**ADC Planning Consultation  
Response from the Historic Buildings Adviser**

| <b>Application Number</b> | Y/59/13 & Y/60/13/L                     |
| <b>Address</b>            | Hobbs Court, Yapton                     |
| <b>Description</b>        | Revisions to Y/3/89, Y/4/89 and Y/60/90 |

Proposed **Structure** at 1:100 scale

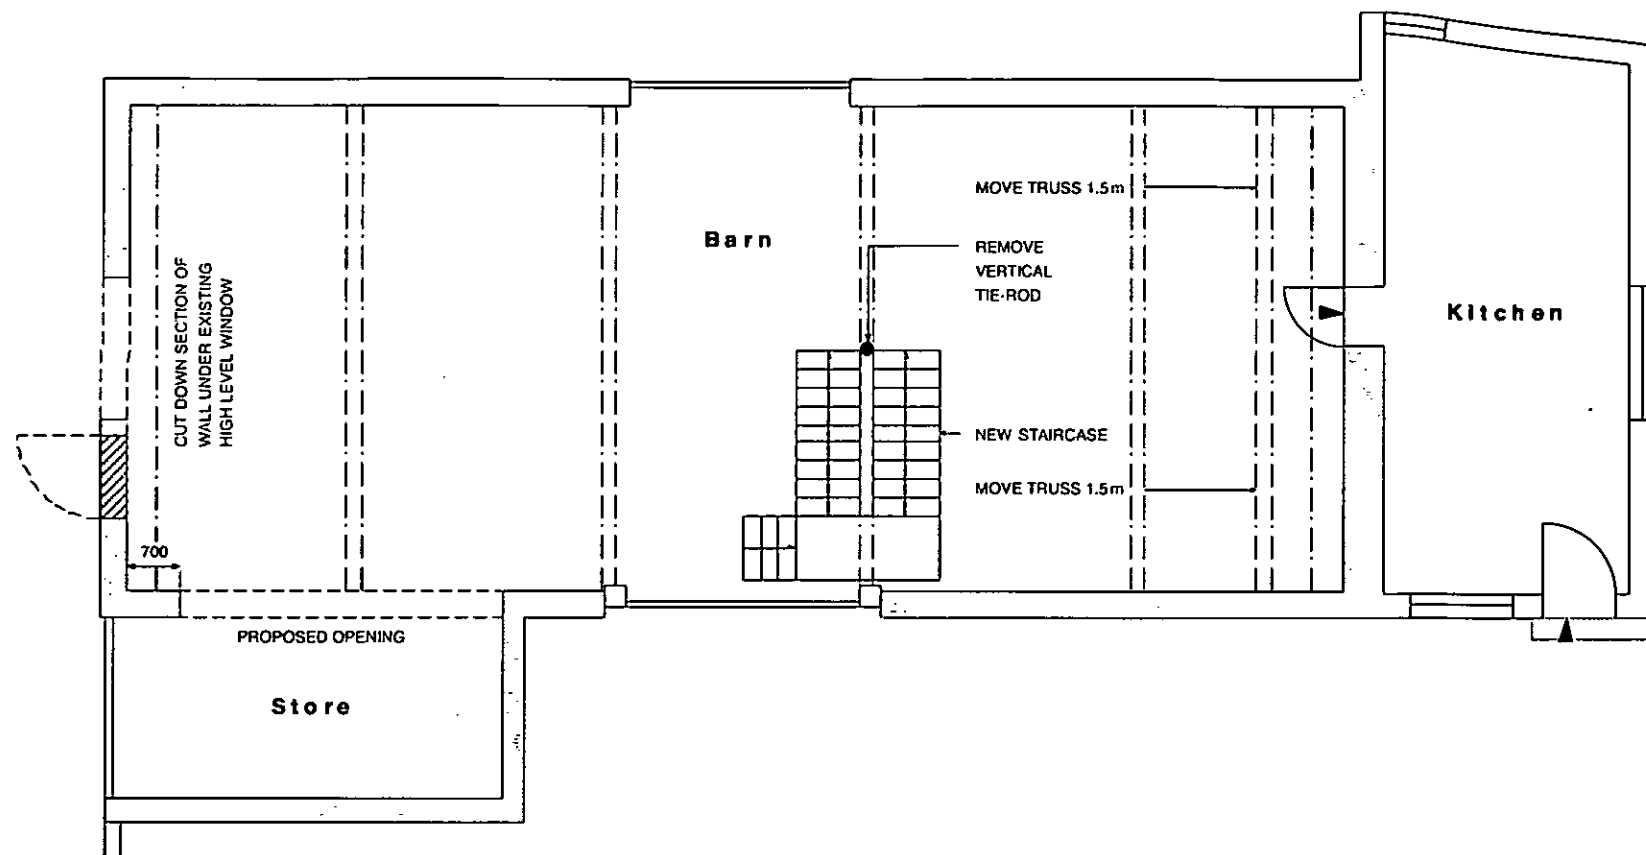
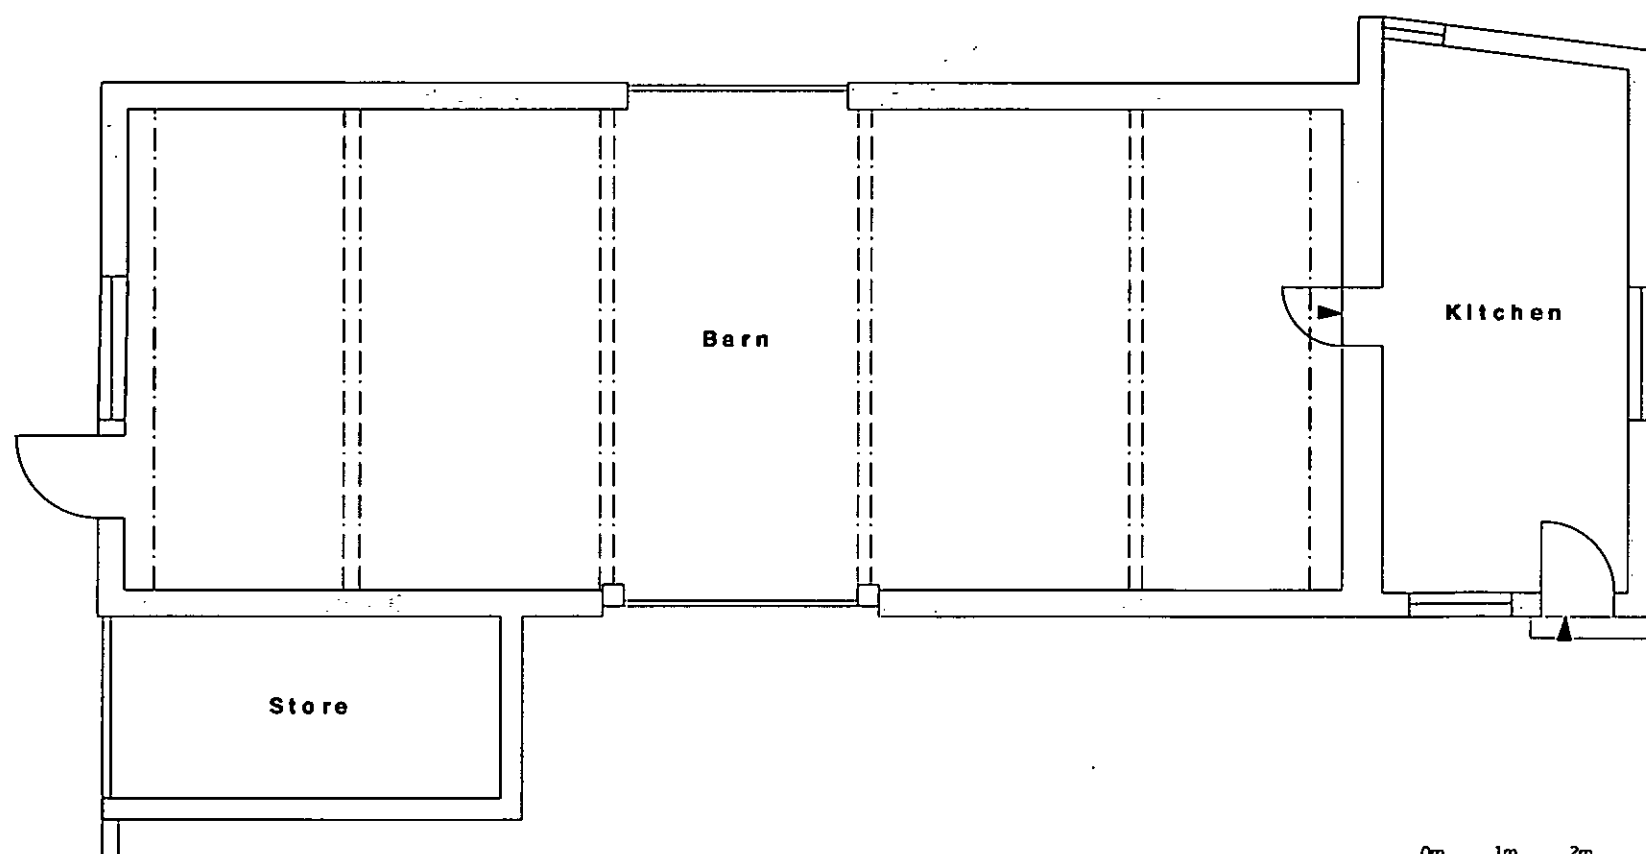
- Staircases in the threshing areas of barns are normally avoided to allow this important space to be expressed more fully. Ideally, the staircase should be located to the side of this space.
- The rooflight to the WC is located in the corner of the roof and as such does not appear sympathetic with the building. Given the low importance of this room, the rooflight should be omitted.
- The rooflight to the study does not appear justified given the level of light here. This should be omitted.
- One of the two rooflights on the front elevation should be removed as this currently appears overly domestic. Two lights are also excessive for the width of the room. If a further light is required, it should be in the rear slope, further to the omission of those proposed (see above).
